**MODIFICATION REQUEST:
Residential and Child Care Centre
Development
14-18 Boondah Road Warriewood
MP10_0177 MOD 9**

Director-General's
Environmental Assessment Report
Section 75W of the
Environmental Planning and Assessment Act 1979

July 2012

ROOF LEVEL
SCALE 1:200

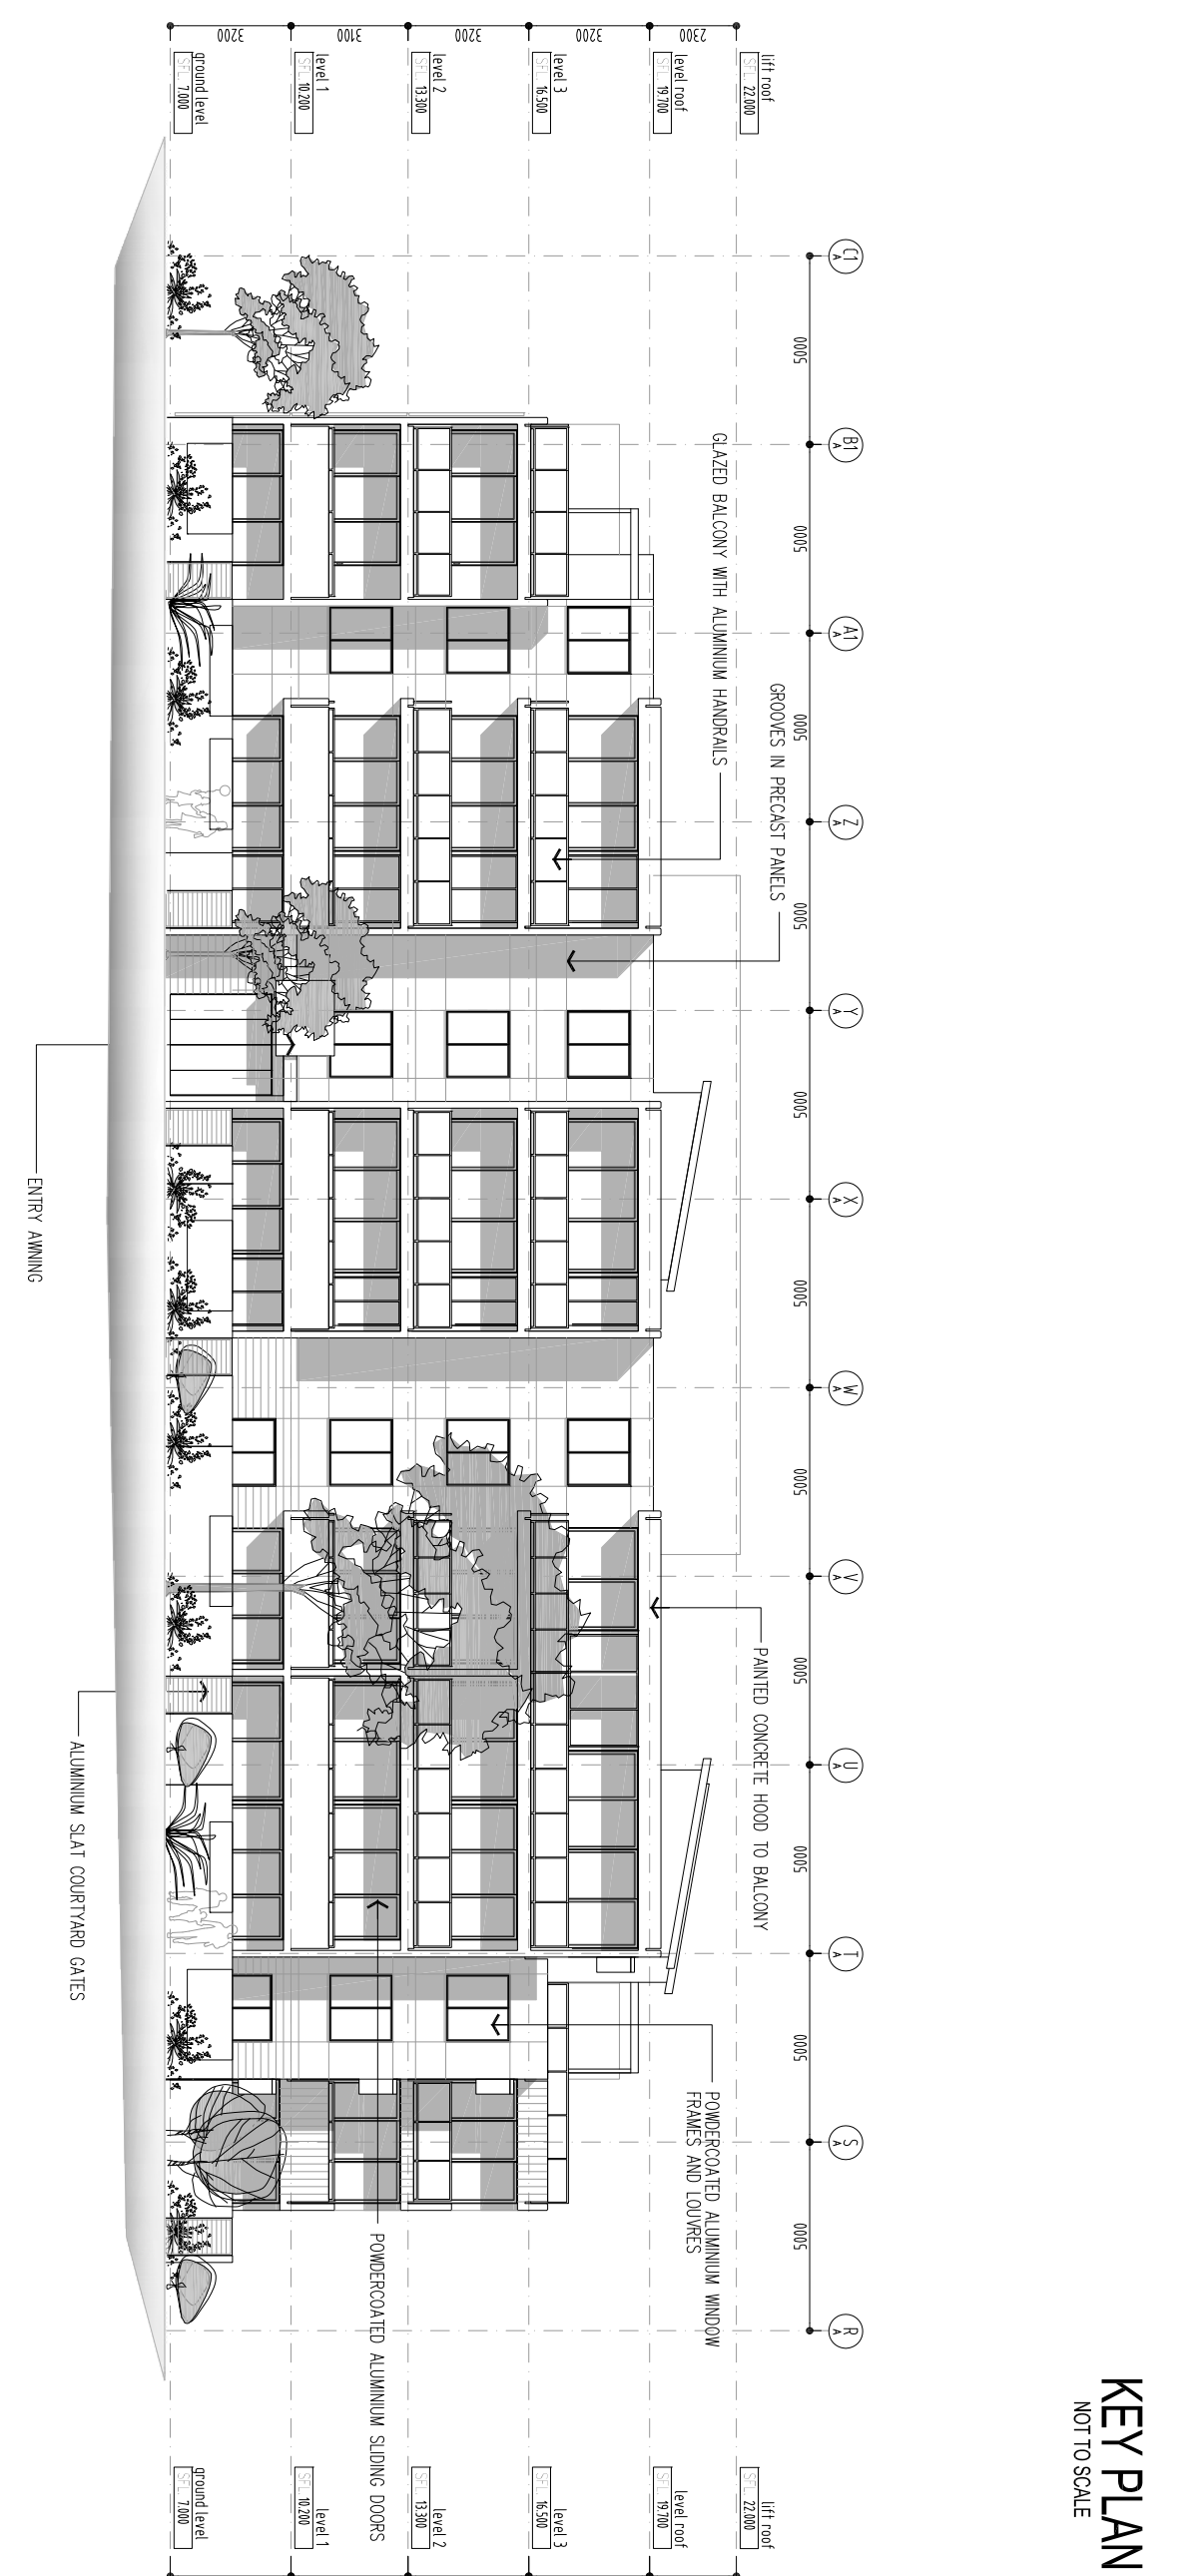
The reconfiguration of windows and door openings to Buildings E and G are considered minor as they relate to small areas of the building's facades. Furthermore, the introduction of 'pop-up' roofs to Building G serves to maintain a design element that has been consistently applied to the majority of approved buildings in the development. The proposed 'pop-up' roofs are depicted in **Figure 3**. Previously approved 'pop-up' roofs are depicted in **Figure 4** belonging to Buildings A and B.

The Department raises no issue with the proposed 'pop-up' roofs and the extension of the roof slab to Building G and E as the impact on bulk and scale is considered negligible and they are consistent with existing design elements of the buildings.
